DEVELOPMENT CONSENT ORDER EN010012 : THE SIZEWELL C PROJECT

ISSUE SPECIFIC HEARING 12 – SESSION 3 Section 4 ii re: BRIDLEWAY 19 LEISTON CUM SIZEWELL

EQUESTRIAN CROSSINGS AT THE SIZEWELL C LINK ROAD ROUNDABOUT

DRAWING TITLE:
 CONSTRUCTION PHASE

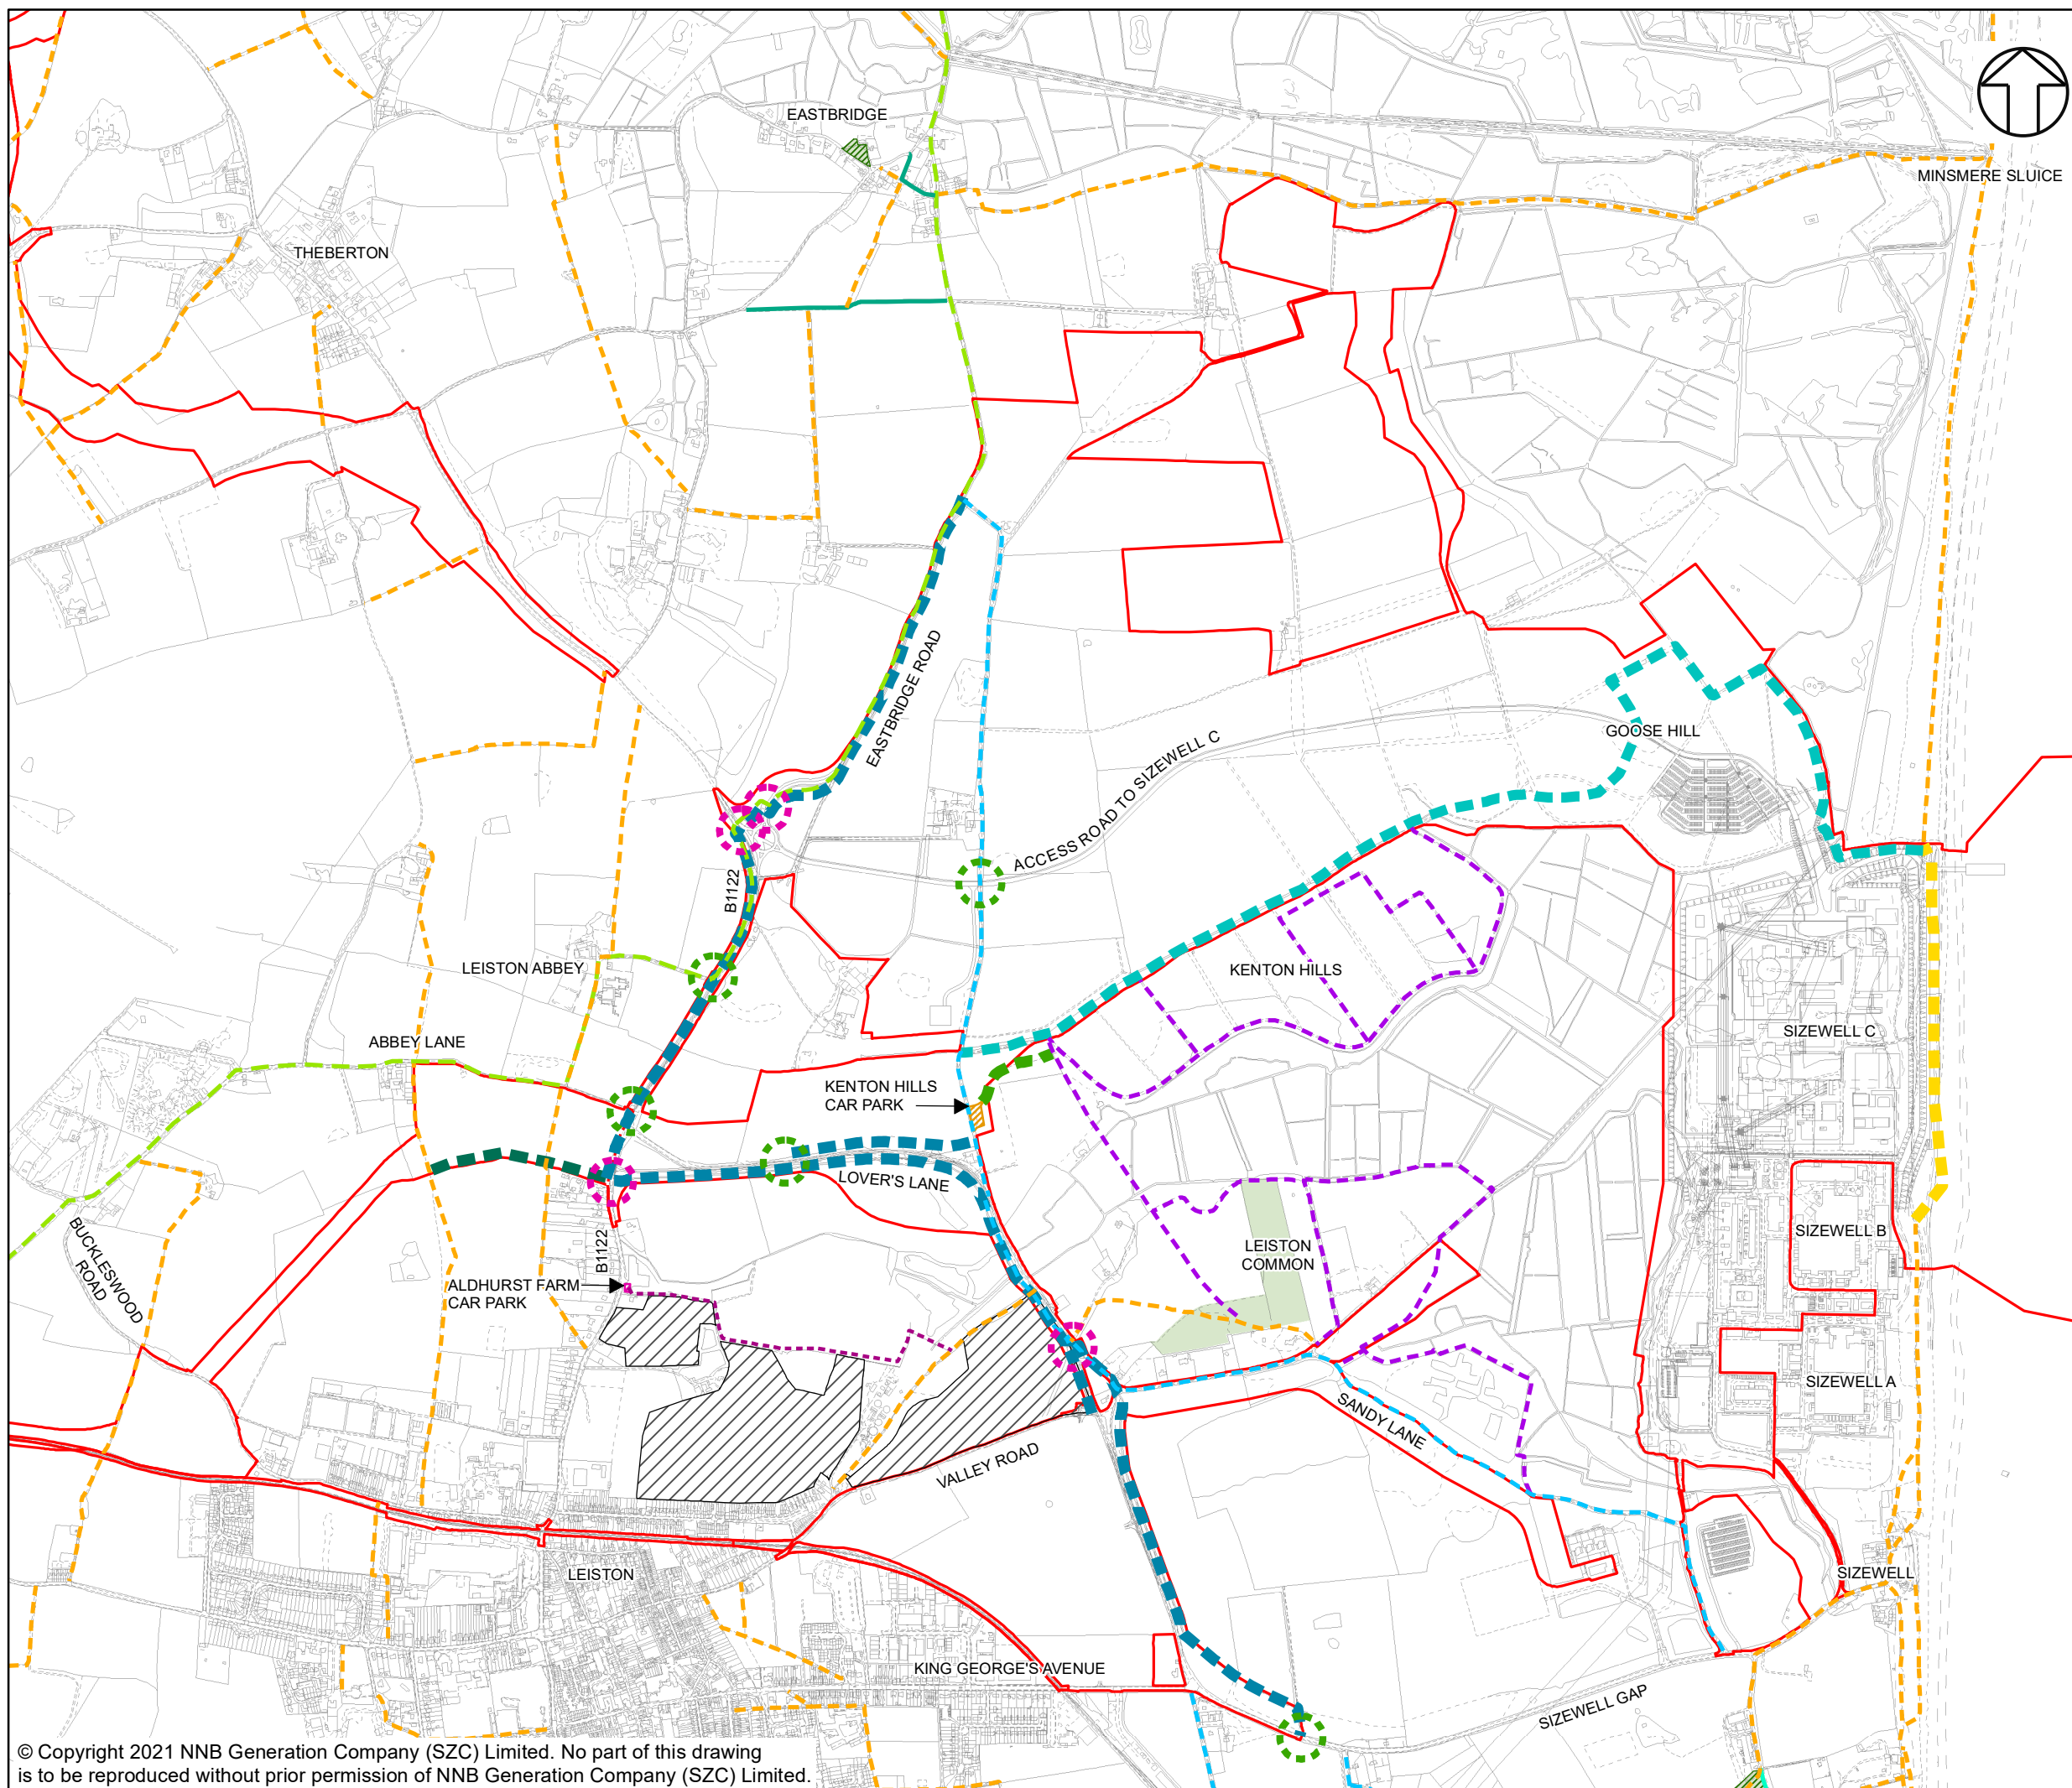
The above clip from Figure 15l.2 of the current Rights of Way and Access Strategy document clearly shows the current alignment of **BR19** (in pale blue) that needs to be closed during construction period. The underlying mapping detail shows the temporary vehicular entry to the construction site from Lover's Lane, and how the alignment of **BR19** will be crossed by the construction of the proposed railway, the internal access and haul roads within the construction site area and the proposed Sizewell Link Road. This is why the northern section of **BR19** will need to be closed before any of the proposed construction works can commence.

This is particularly concerning where the alternative route for **BR19** will cross the construction of the Sizewell Link Road/Eastbridge Road roundabout on the B1122.

Temporary crossings for horse riders, cyclists and pedestrians during the proposed construction of this roundabout and junction are totally unacceptable. There will be movements of traffic, including heavy construction traffic, ground workers and associated plant and machinery. There will be safety barriers, flashing lights, and a high volume of noise. This construction location will not be a suitable thoroughfare for horse riders, or indeed cyclists and pedestrians.

It is therefore clear that while the quick win of the off road sections for the temporarily diverted northern section of **BR19** are achievable prior to the commencement of the proposed construction of the Sizewell C site, there will be no provision for safe crossing by members of the public at the road crossings, the proposed railway crossing and in particular the construction site of the Sizewell C Link Road/Eastbridge Road roundabout on the B1122.

The above clip from Figure 15l.2 of the current Rights of Way and Access Strategy document clearly shows the proposed roundabout, with the proposed Pegasus crossings to be constructed as a part development of the new road and roundabout.

This proposed roundabout has five entry/exits which will be taking merged traffic to and from the proposed new Sizewell Link Road and the B1122. The proposed Pegasus crossings are to the north of the roundabout and there will be significant goods traffic including heavy plant movements in both directions on this busy intersection.

While this junction of the B1122 is not a dual carriageway, there will be traffic entering and exiting from the roundabout, possibly in two separate lanes in each direction, giving horse-riders up to four traffic lanes to cross. At times of heavy traffic flow horses may have to wait a significant amount of time while the traffic is controlled by the lights.

Horses do not have brakes, and will find using the double Pegasus crossing at this roundabout distressing due to proximity to the movement, noise and particularly the sound made by airbrakes of heavy goods vehicles and construction traffic suddenly held up by the crossing lights.

The above clip from Figure 15l.2 of the current Rights of Way and Access Strategy document shows the design of the roundabout and the position of the proposed two Pegasus light controlled crossings

Any temporary crossings for horse riders, cyclists and pedestrians during the proposed construction of this roundabout and junction would be totally unacceptable. There will be movements of motor vehicles, including heavy construction traffic, ground workers and associated plant and machinery. There will be safety barriers, flashing lights, and a high volume of noise. This construction location will not be a suitable thoroughfare for horse riders, or indeed cyclists and pedestrians.

The intention stated in Section 1. 2. 23 of the current Rights of Way and Access Strategy document to make the new off-road route a definitive right of way also lends weight to the consideration of the design of the crossing into the future. An underpass would seem to be the best solution to provide a safe off-road route for all non-motorised users that would avoid a dangerous at grade crossing of this busy intersection.

CONCLUSION: If a way can be found to fulfil the requirements of the Development Consent Order, a safe grade separated design for non-motorised users must be considered for the Sizewell C Link Road/Eastbridge Road roundabout on the B1122.
